Development Management
Lincolnshire County Council
County Offices
Newland
Lincoln LN1 1YL
Tel: 01522 782070
developmentmanagement@lincolnshire.gov.uk

Application Ref: H16-0692-25

Proposal: **Development of site to provide a food store and drive-thru, along with all associated works and access**

Location: **Land to the south of Holbeach Road, Spalding, Lincolnshire, PE12 6JP**

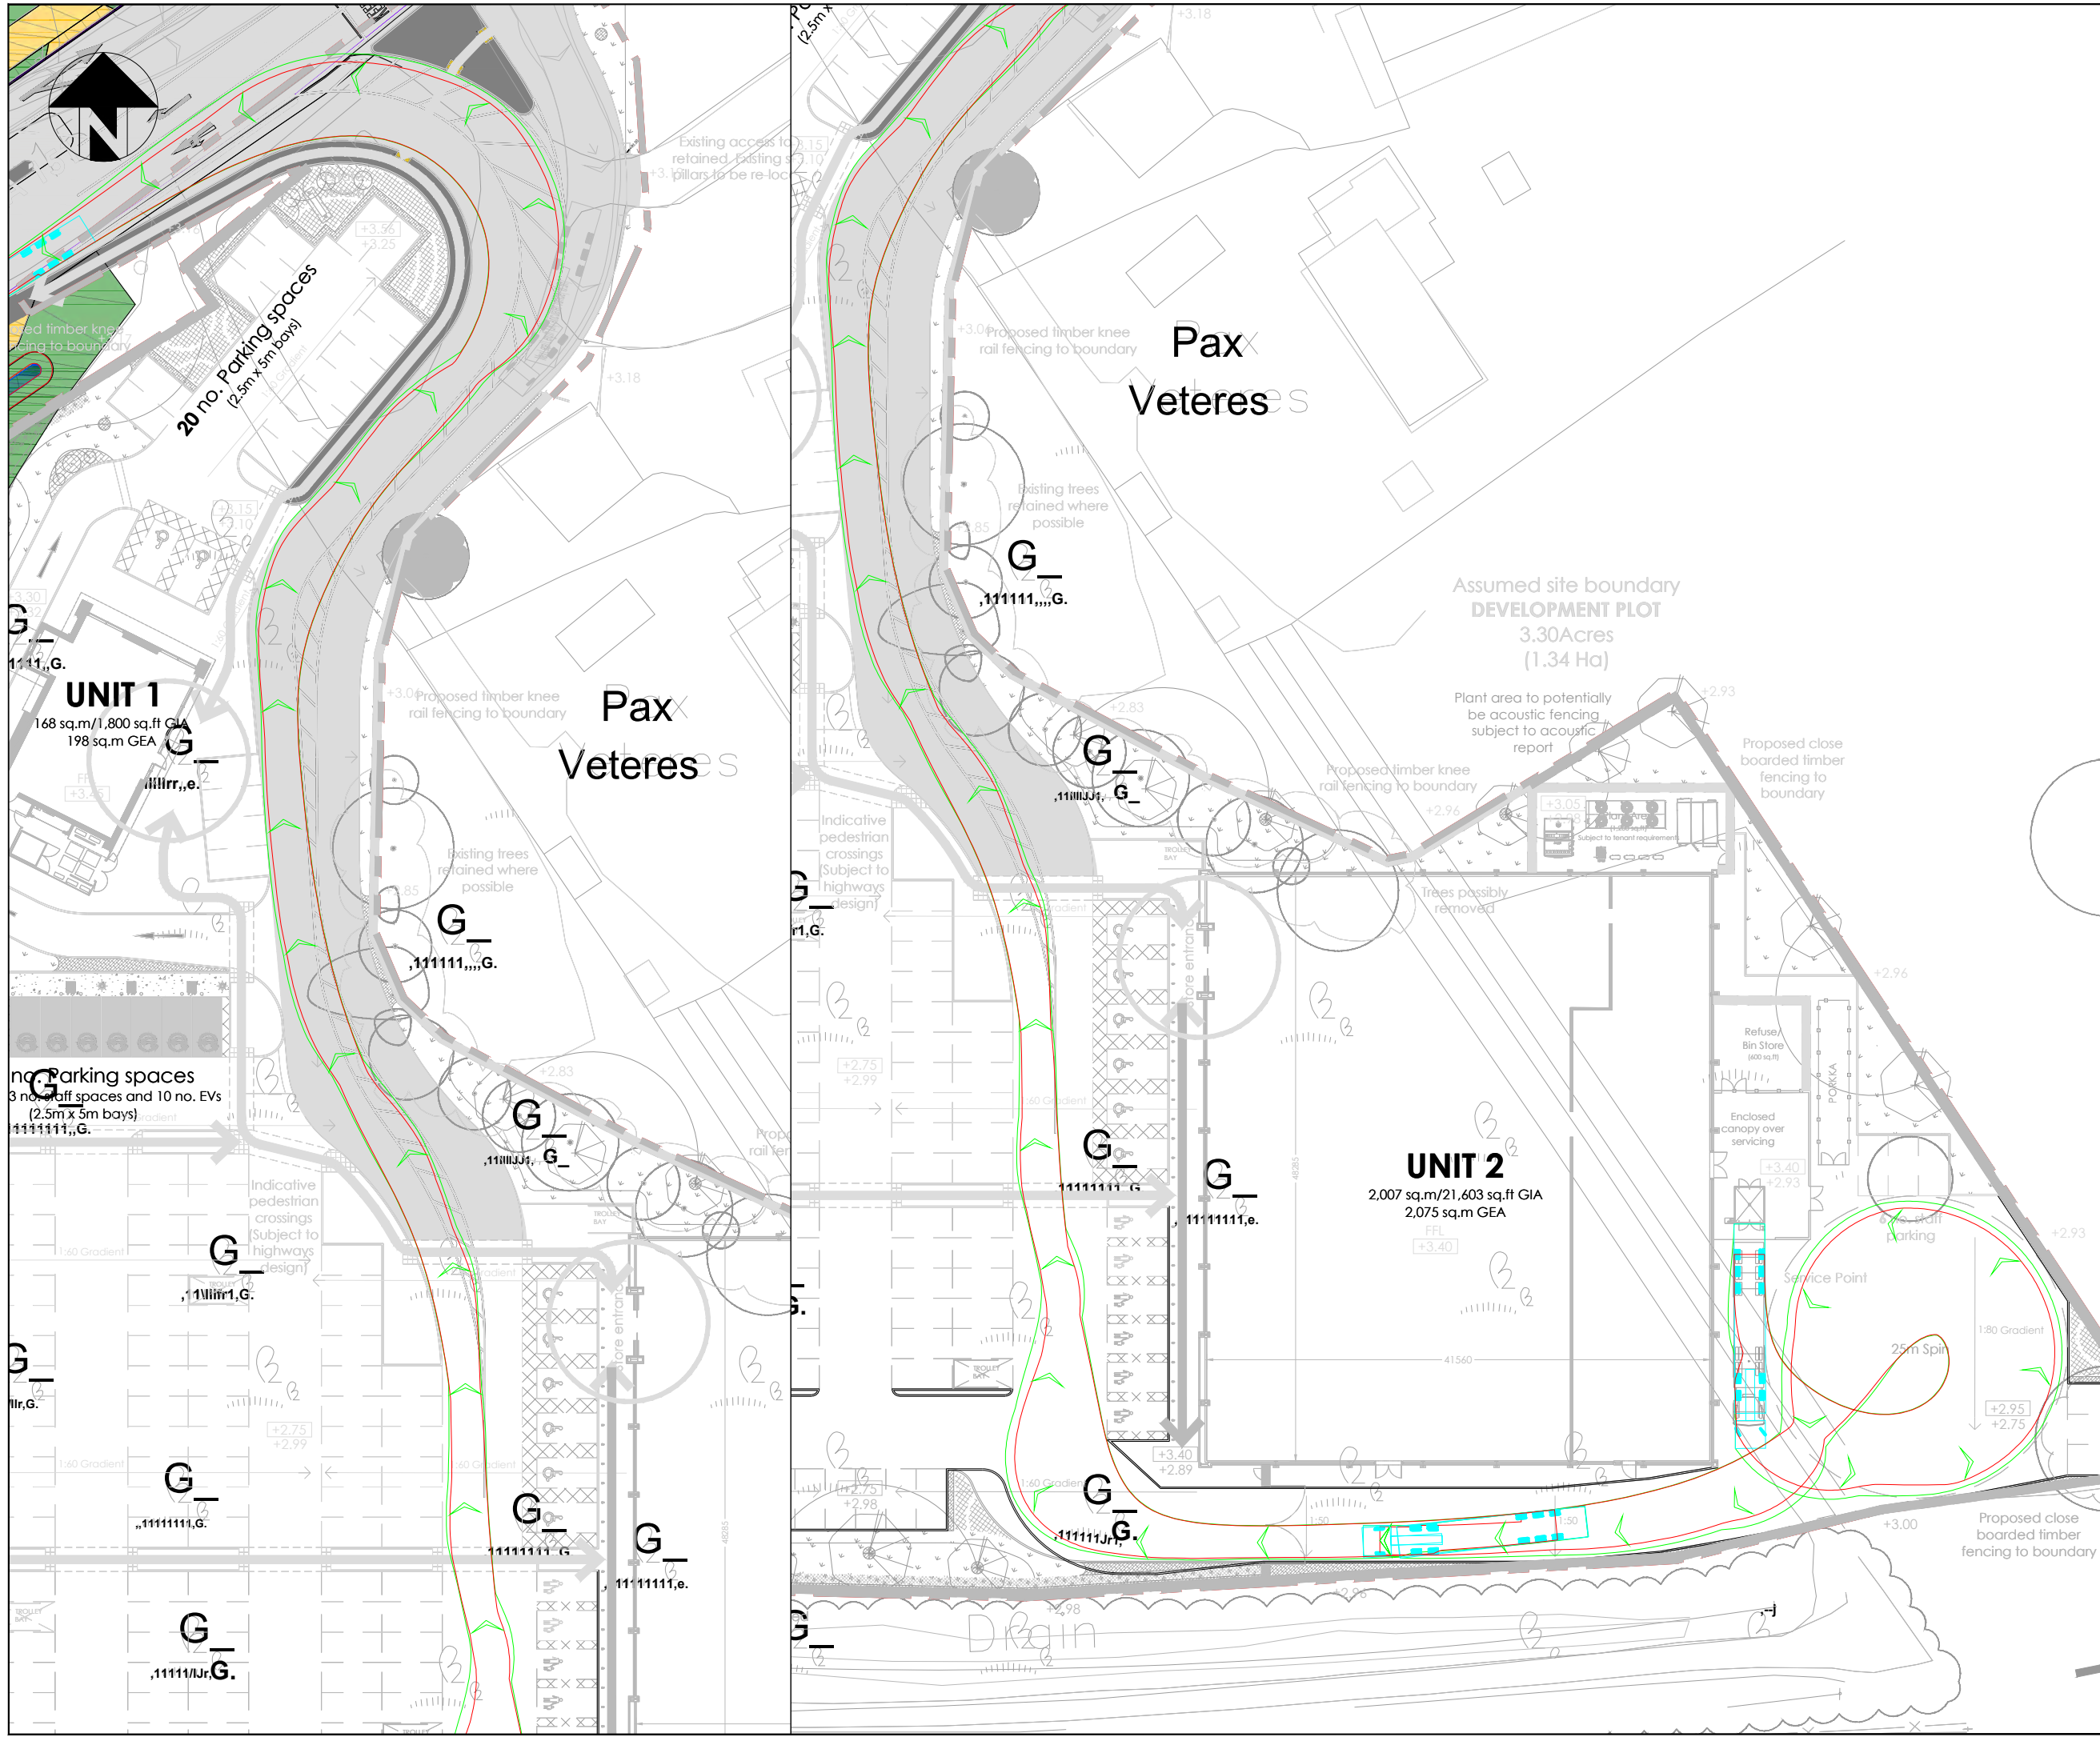
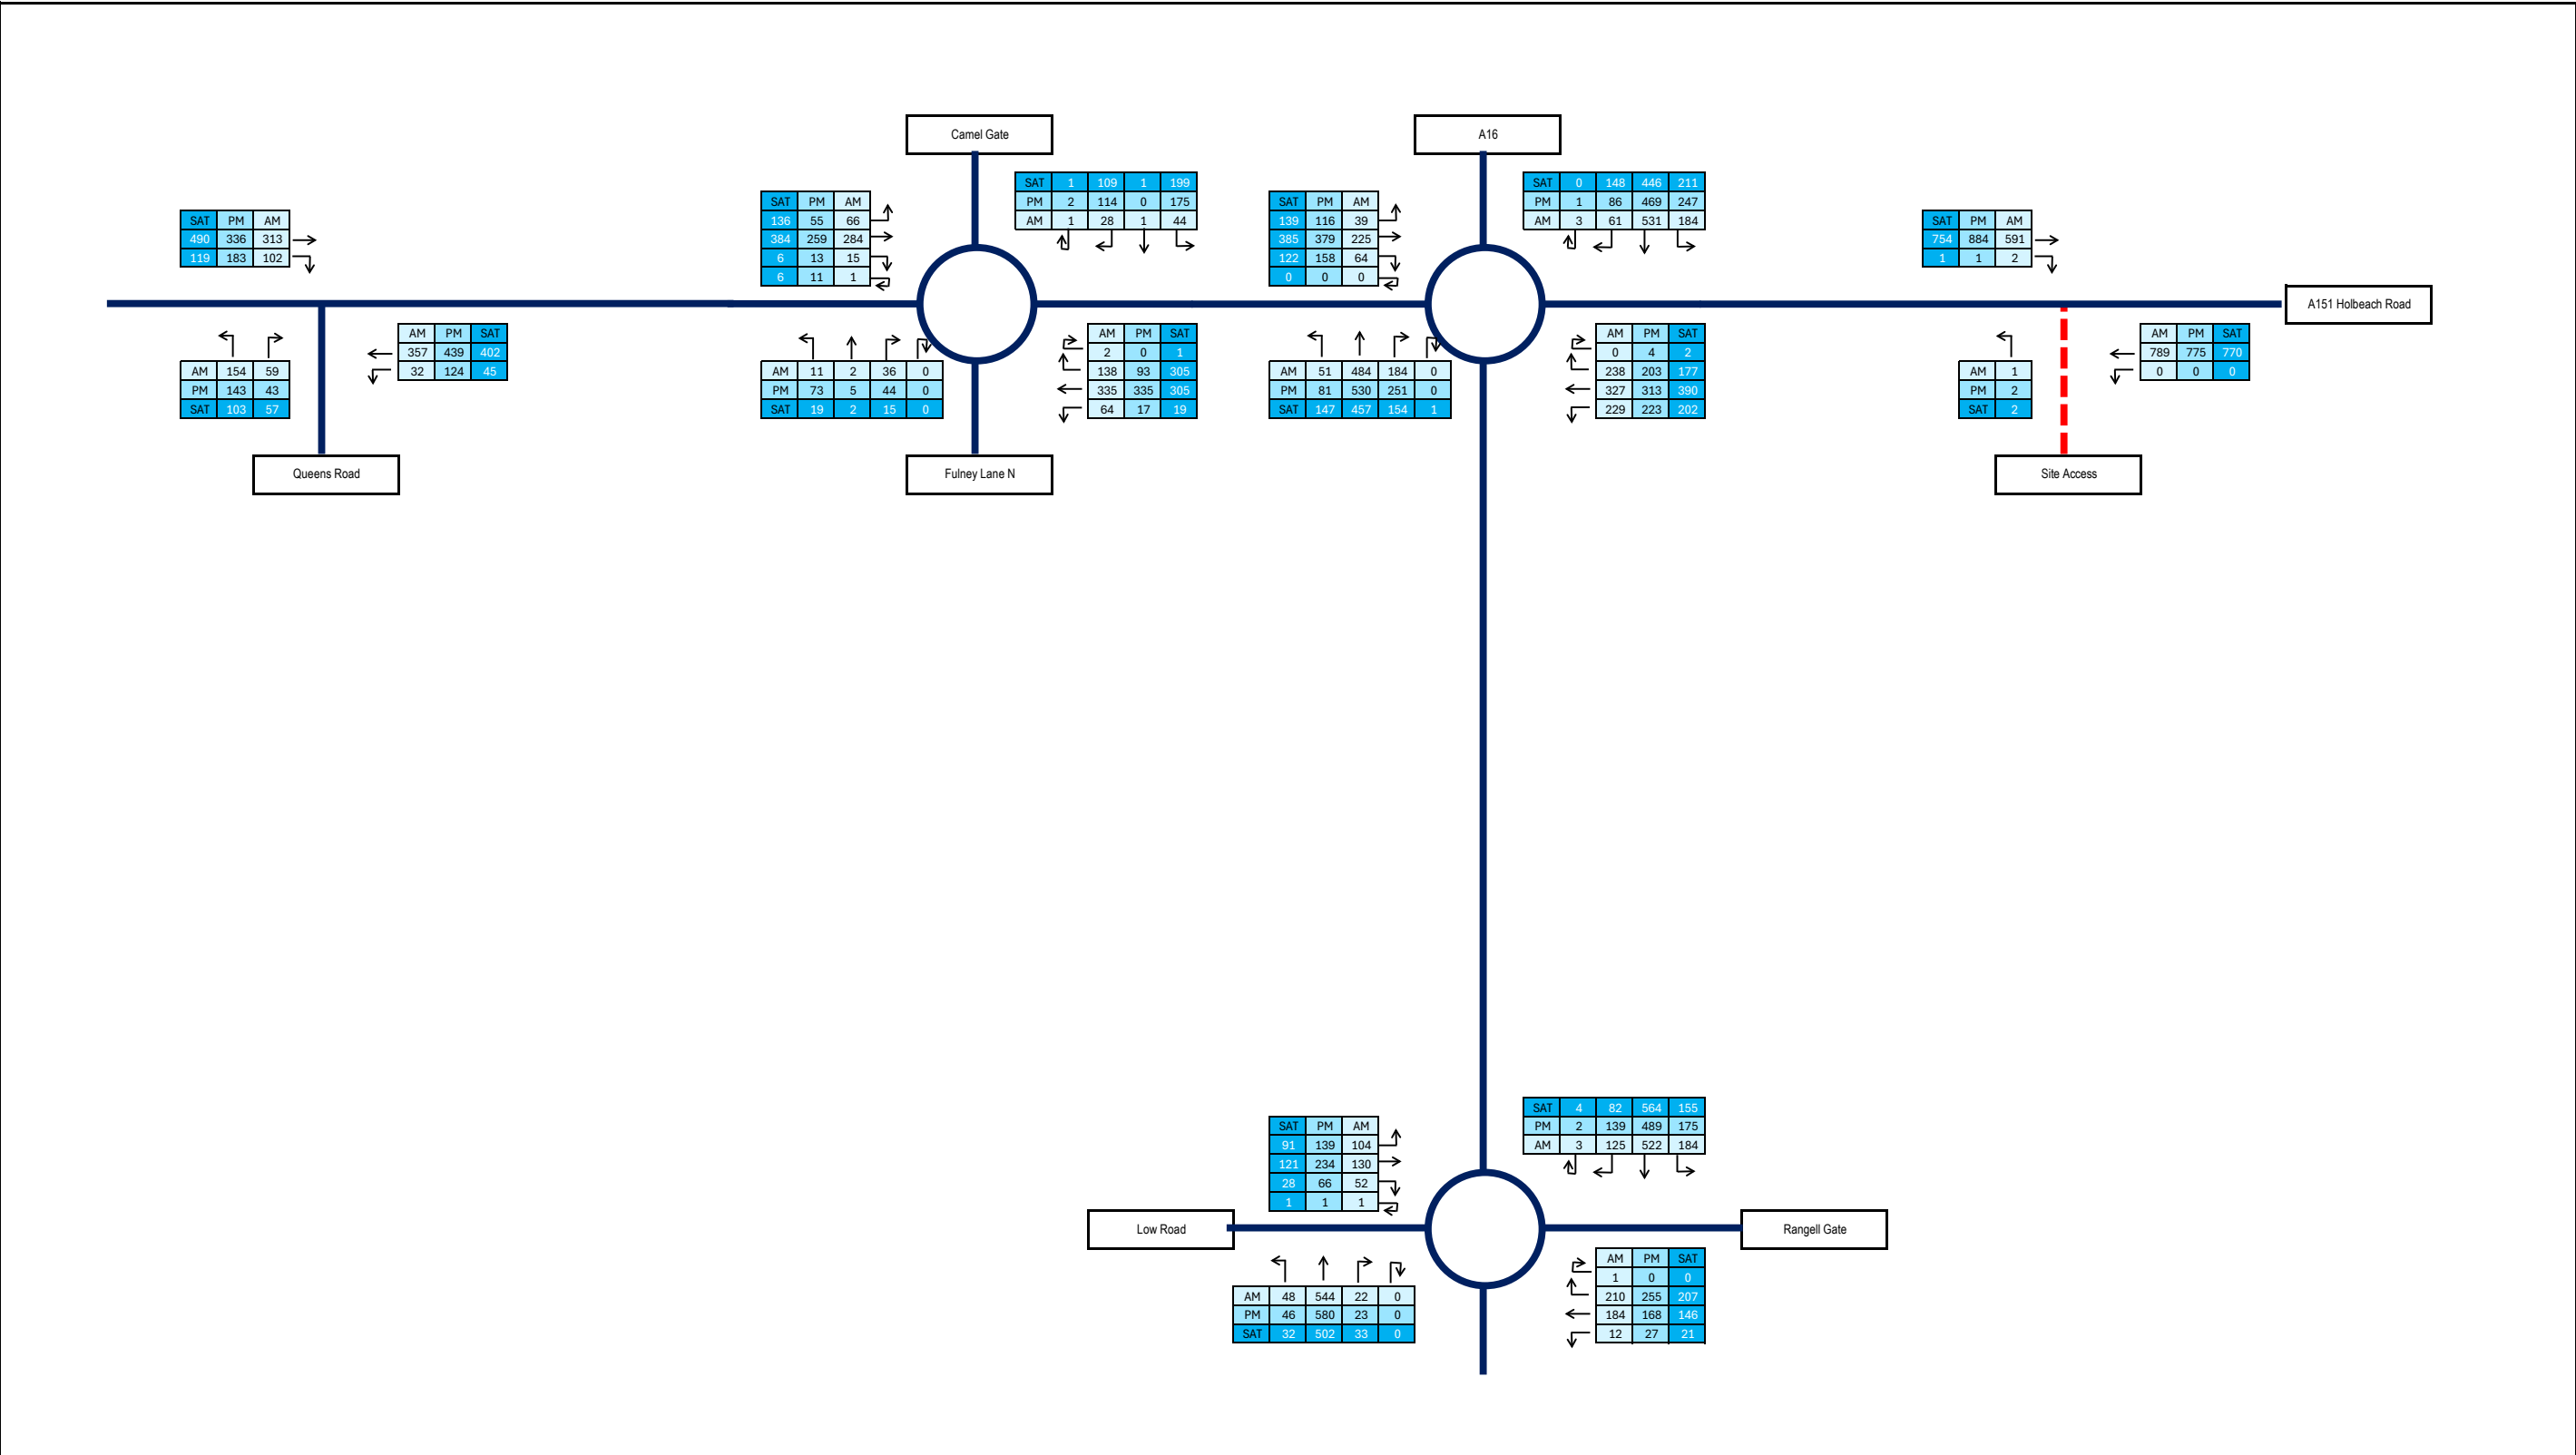
The tracking is unworkable at peak hours as HGV's will need to take up both lanes exiting the site. The swing that is needed can't be achieved on the access road without moving the stone pillars – we need security that they can be moved.
